**Concept Proposal for the Redevelopment of Cockle Bay Wharf
Notification of Exhibition (SSD 7684)**

TAB A – Detailed Comments on the Concept Proposal for the Redevelopment of Cockle Bay Wharf

Truck Routes - Approach Routes

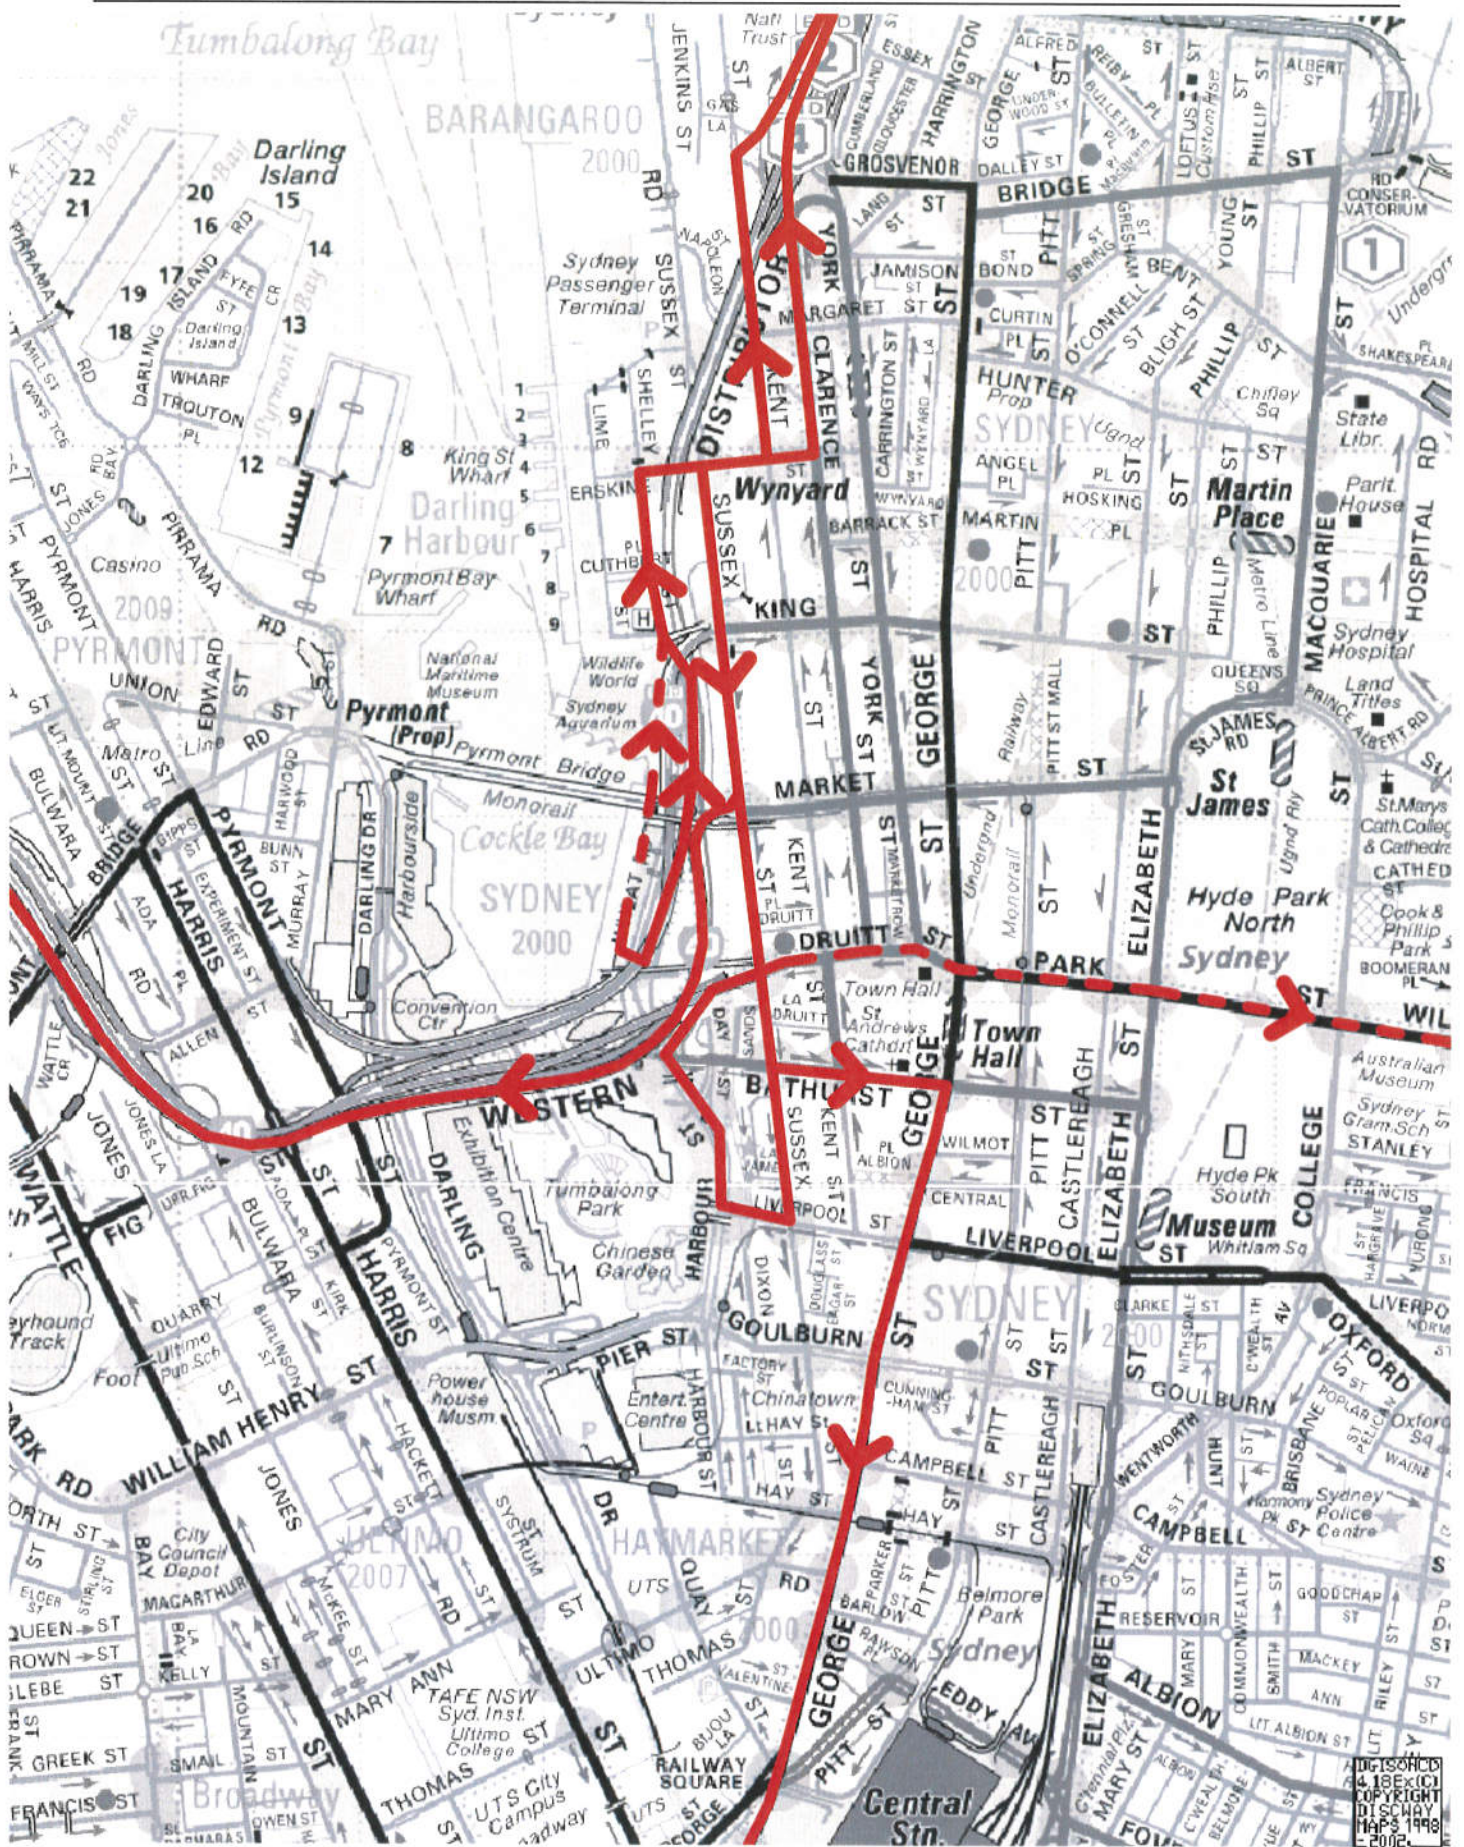
- The demolition or partial closure of pedestrian bridges between Darling Harbour and the CBD, especially during events at Darling Harbour;
- The partial closure of the Western Distributor, Harbour Street and Wheat Road;
- The accommodation of trucks within designated work zones/temporary construction compounds adjacent to construction activity;
- The installation of a temporary set of traffic signals at the intersection of Harbour Street/Blackwattle Place;
- The use of George Street for truck approach routes during and after the Sydney Light Rail construction; and
- The use of York, Erskine and Sussex Streets for truck approach routes during bus operation.

- Cumulative construction impacts of projects including Sydney Light Rail Project, Sydney Metro City and Southwest Project and IMAX Redevelopment Project. Existing CPTMPs for developments within or around the development site should be referenced in the CPTMP to ensure that coordination of work activities are managed to minimise impacts on the road network; and
 - Should any impacts be identified, the duration of the impacts and measures proposed to mitigate any associated general traffic, public transport, pedestrian and cyclist impacts should be clearly identified and included in the CPTMP.
- Submit a copy of the final plan to the Coordinator General, CBD Coordination Office for endorsement, prior to the issue of any construction certificate.

## Pedestrian Desire Lines

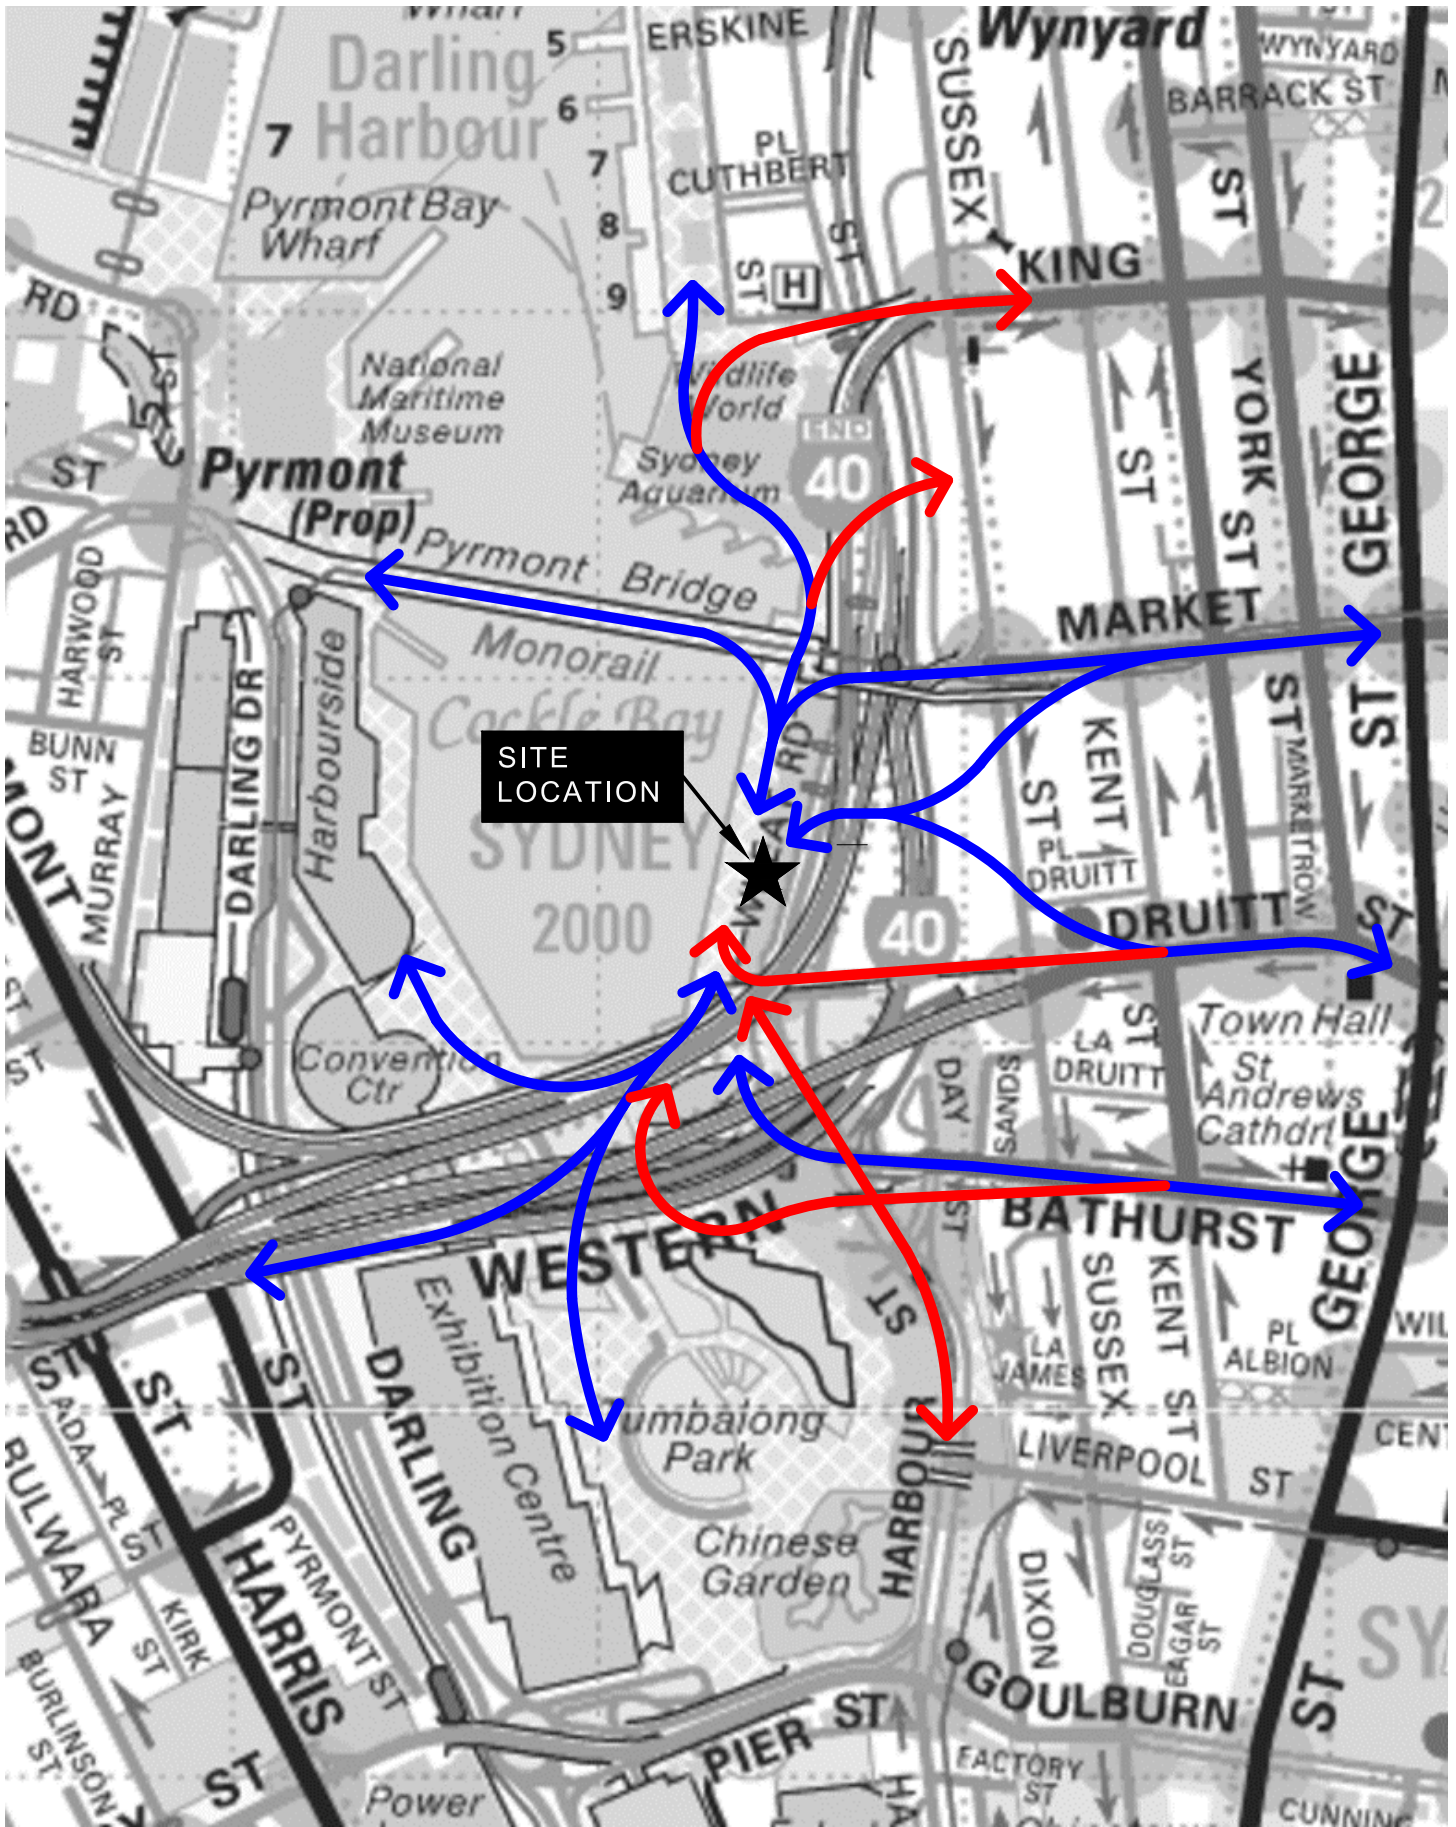
A review of the Pedestrian Assessment undertaken for the proposed development indicates that there may be opportunity for improving the Route 4 (Druitt Street Bridge) entry access point from the Darling Harbour waterfront and increasing its capacity to accommodate Darling Harbour workers and visitors (including during events) for the Darling Harbour precinct. TfNSW advises that the enhancement of Route 4 provides an opportunity to improve access to the Darling Harbour precinct by providing it with a quick and direct link to the heavy rail network at Town Hall Station, the planned Sydney Metro at Pitt Street Station, the Sydney Light Rail on George Street and bus services on Druitt Street, not offered under any other pedestrian route between Darling Harbour and the CBD.

- Confirms if the identified potential enhancements to pedestrian Routes 1, 2 and 4 form part of the proposed development and provide more detail on each route's enhancement;
- Considers improving the entry access point to Route 4 (Druitt Street Bridge) from the Darling Harbour waterfront and increasing its capacity to accommodate Darling Harbour workers and visitors (including during events) to provide a quick and direct link to the CBD and public transport network, as part of the proposed development in consultation with the CBD Coordination Office; and
- Considers improving the cycleway connections between Pyrmont/Bays Precinct and the CBD by connecting the existing pedestrian/cycle infrastructure on the Western Distributor with the King Street and Kent/Liverpool Street cycleways via the development site, in consultation with the CBD Coordination Office.
